Our ref: Waste Management Facility, Botany (SSD-62855708)

Subject: Request for Information in Submissions Report

Waste Management Facility, Botany Request for Further Information

APPENDIX D

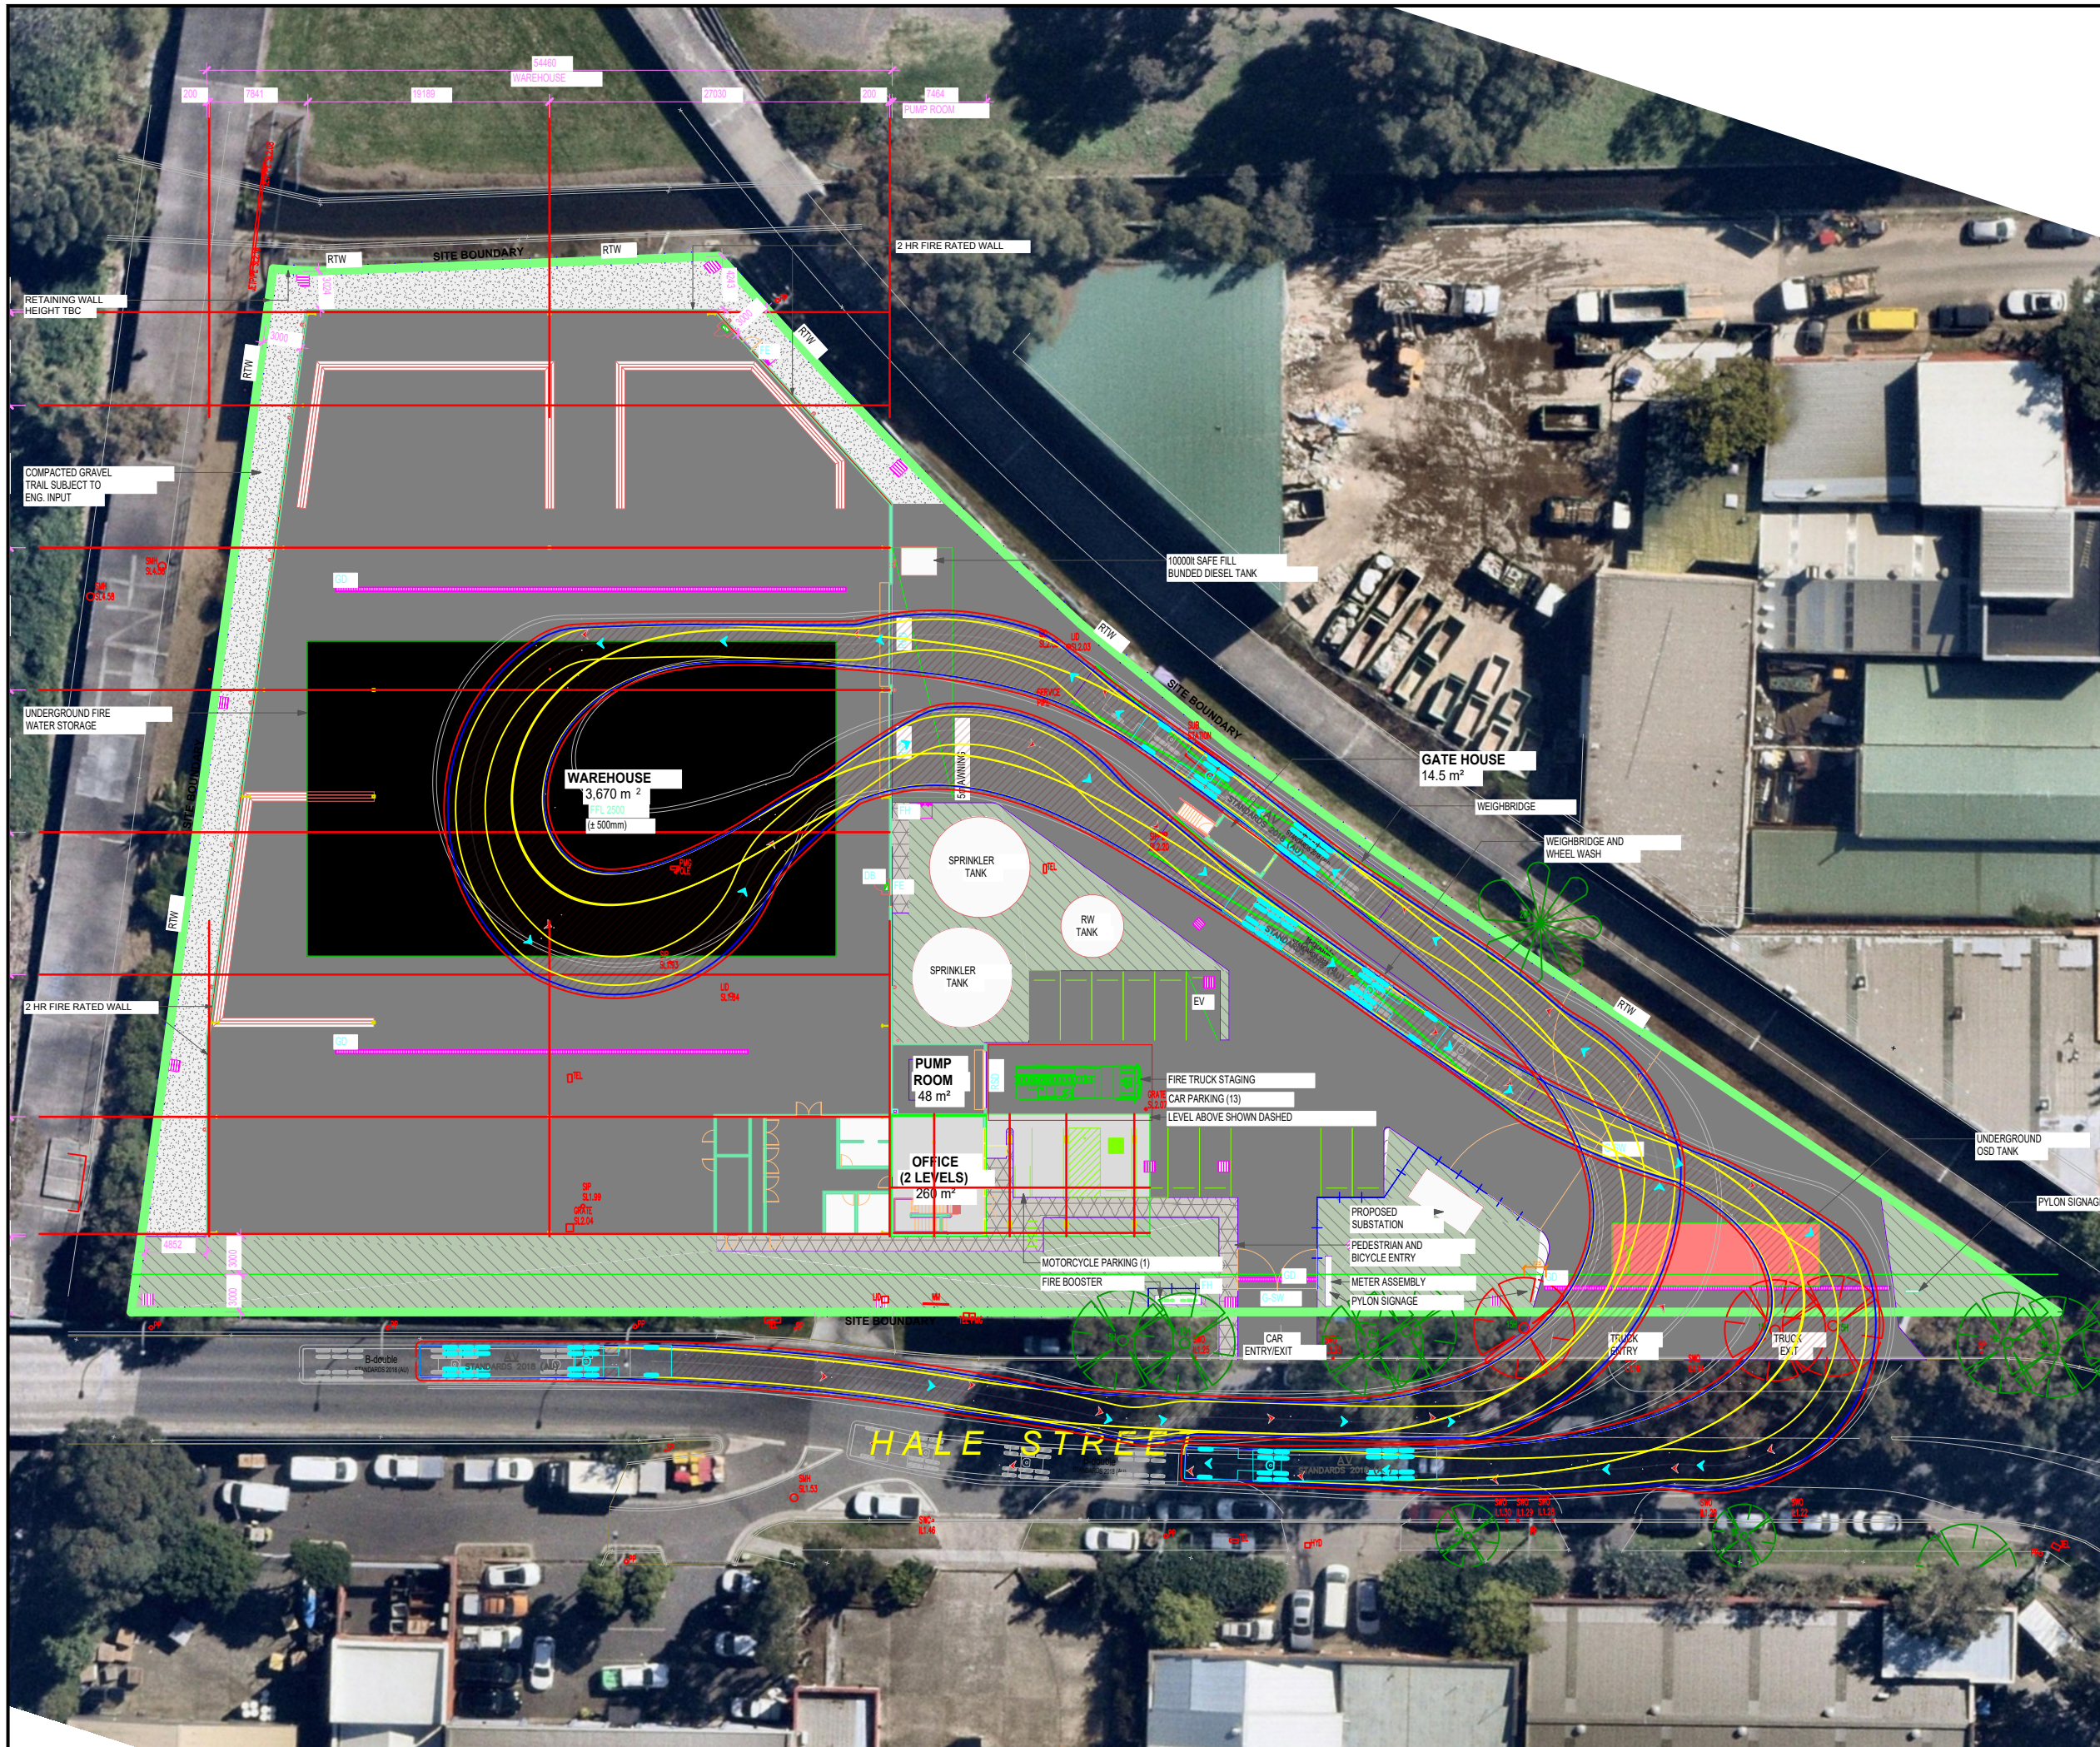
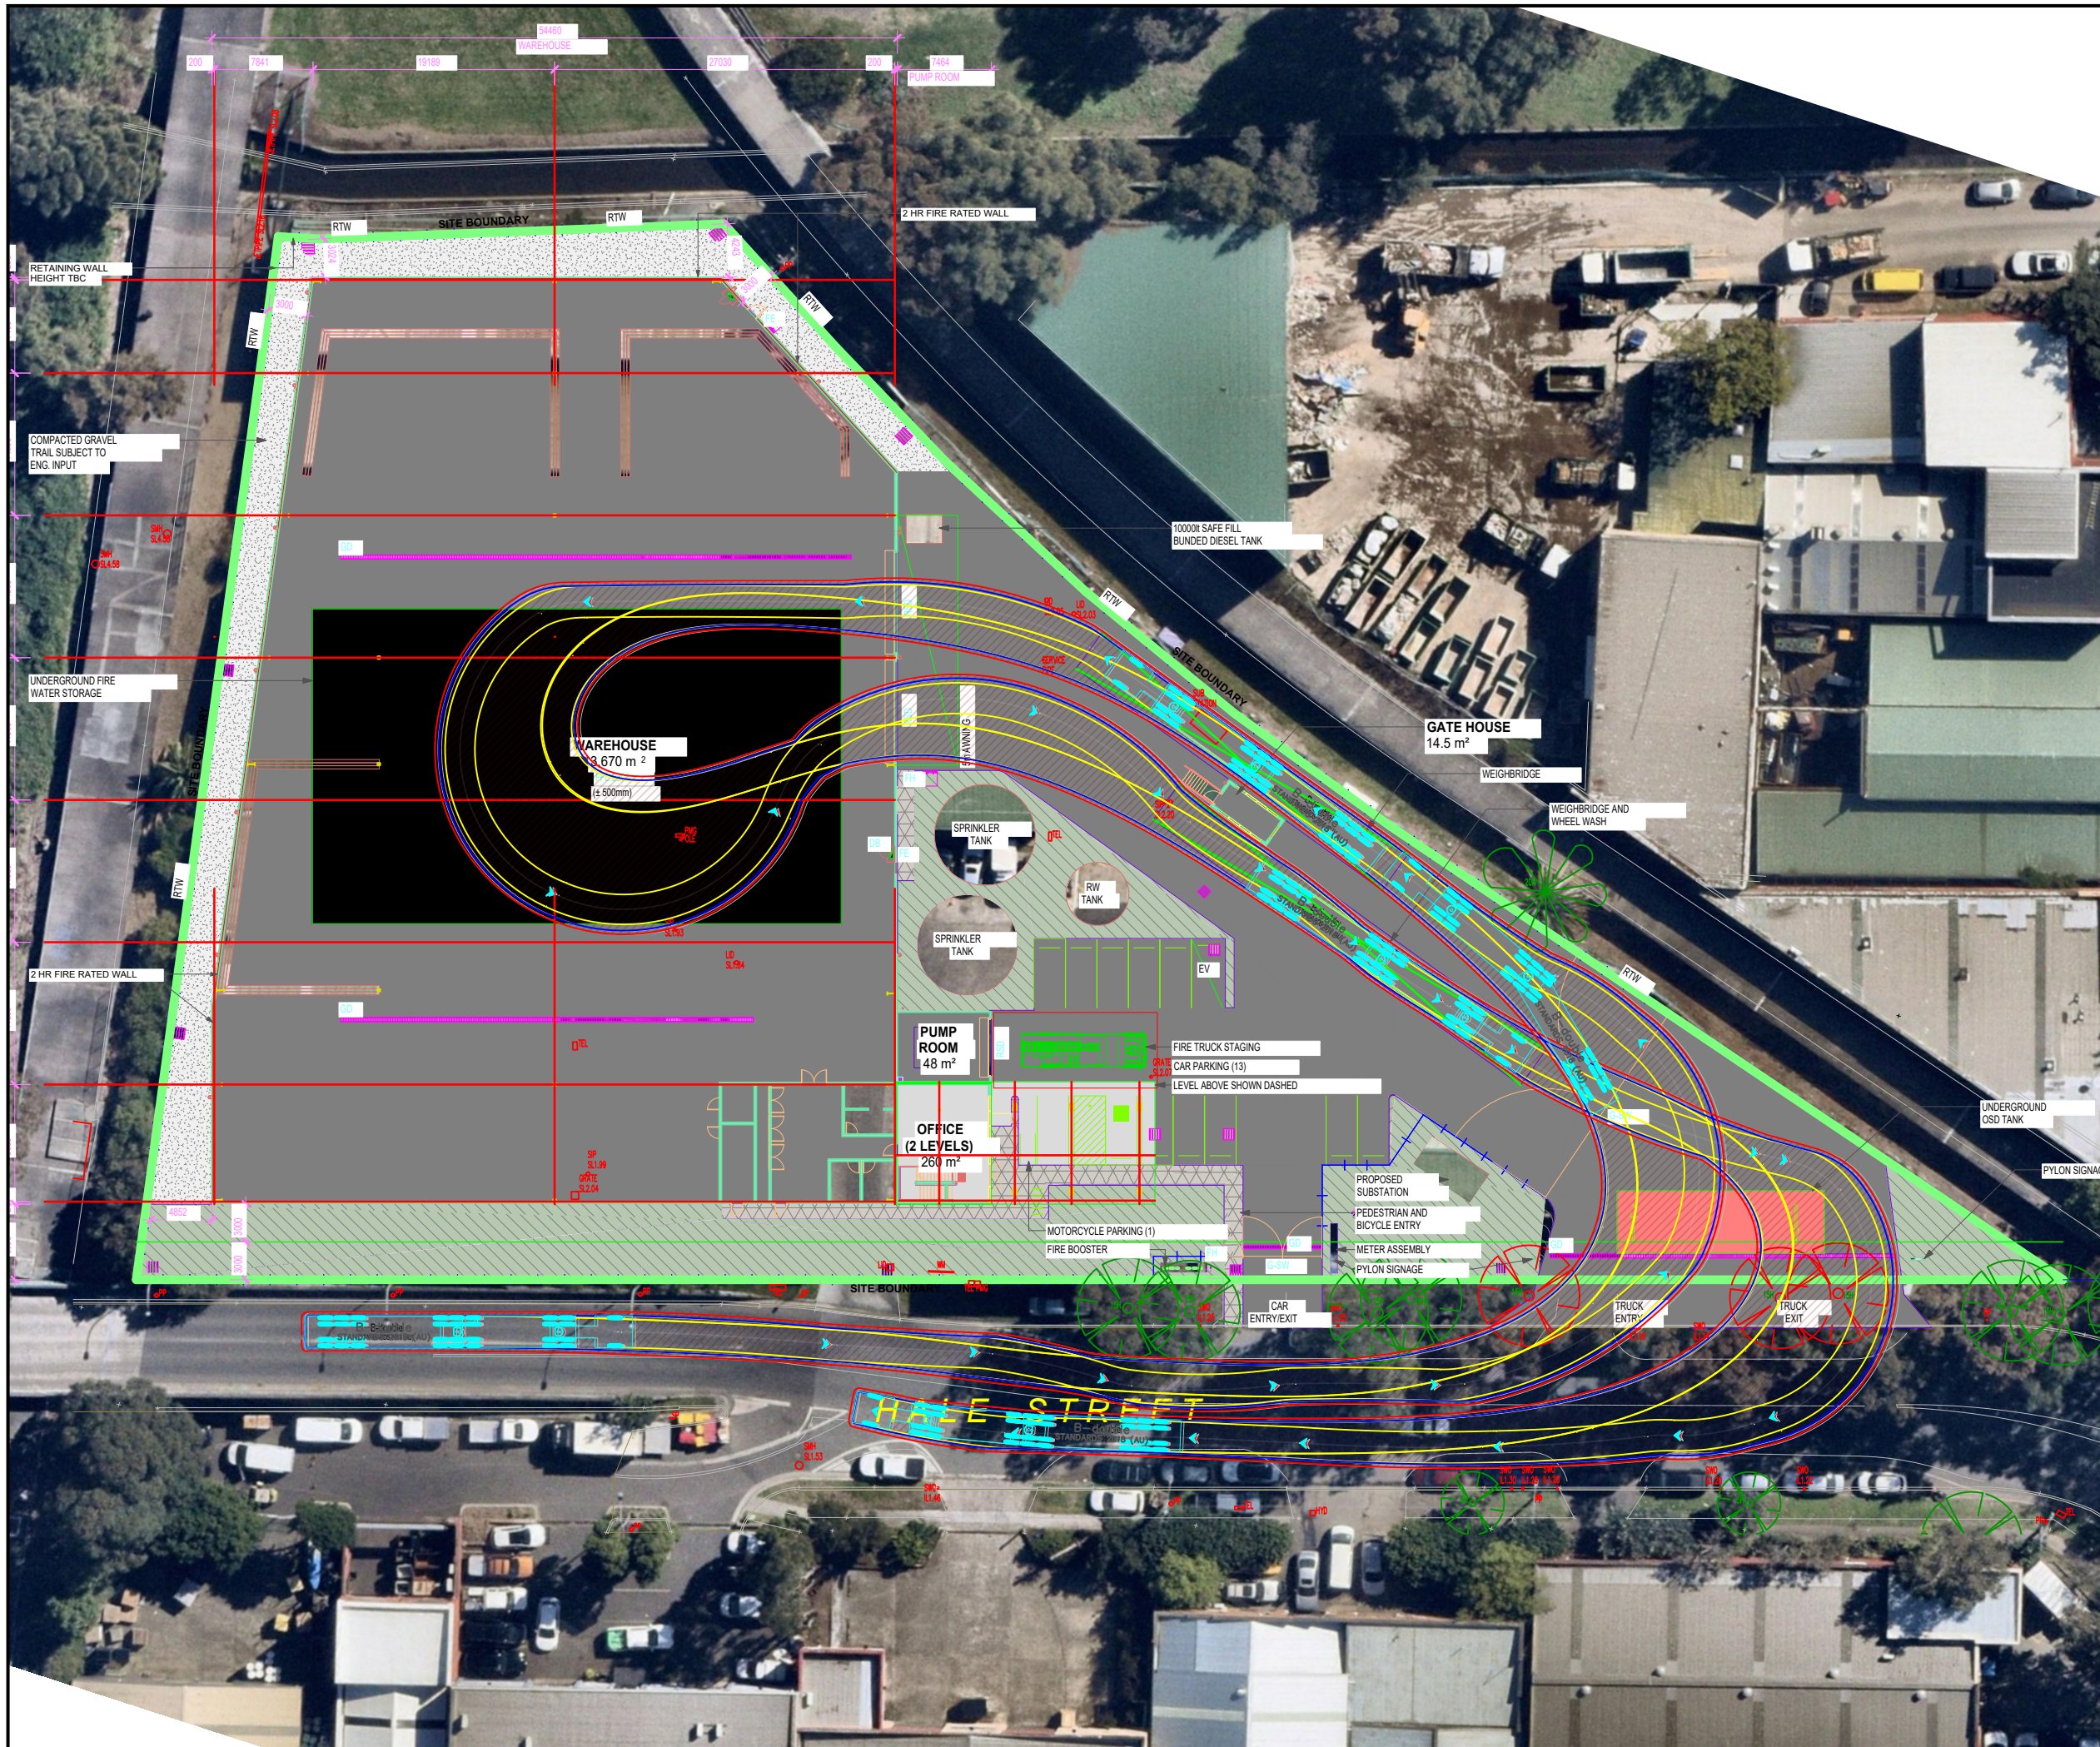
The swept path analysis for the site access driveway provided at Appendix D of the TIA is unclear and indicates there may be conflict between two B-doubles travelling eastbound and westbound on Hale Street.

Recommendation: Revised swept path analyses are required for 20 metre articulated vehicles and B-doubles accessing the site that clearly demonstrates the centreline of Hale Street will not be crossed and there will be no conflict with on-street parking. All line marking on Hale Street must be clearly marked.

Figure 8 - Proposed Stormwater Connection

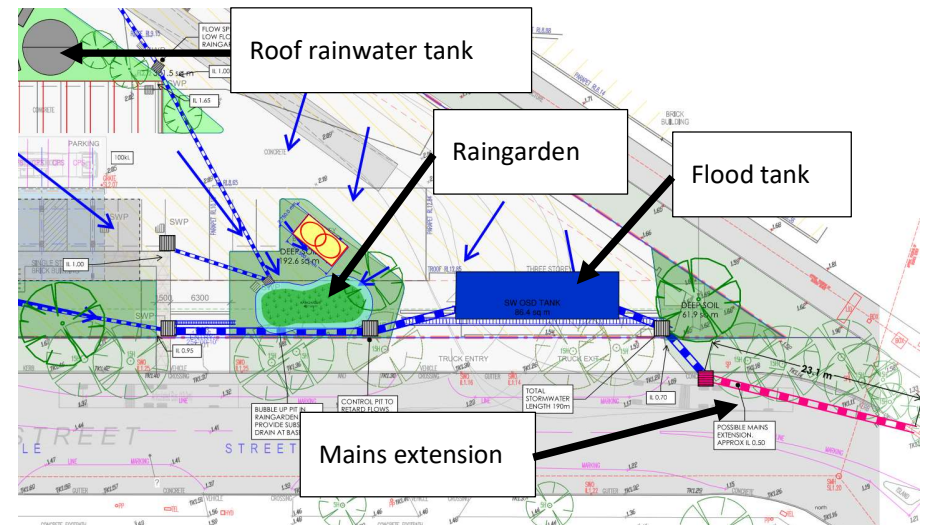
The IWMS states a new stormwater discharge point and inlet pit will be installed at the front of the site on Hale Street, with a proposed 22 metre extension to Council's stormwater drainage system on Hale Street. Insufficient design details have been provided regarding this extension and the environmental impacts of these works have not been assessed.

Recommendation: Additional information is provided regarding the design of the proposed stormwater discharge point and extension, including consideration of any associated environmental impacts.
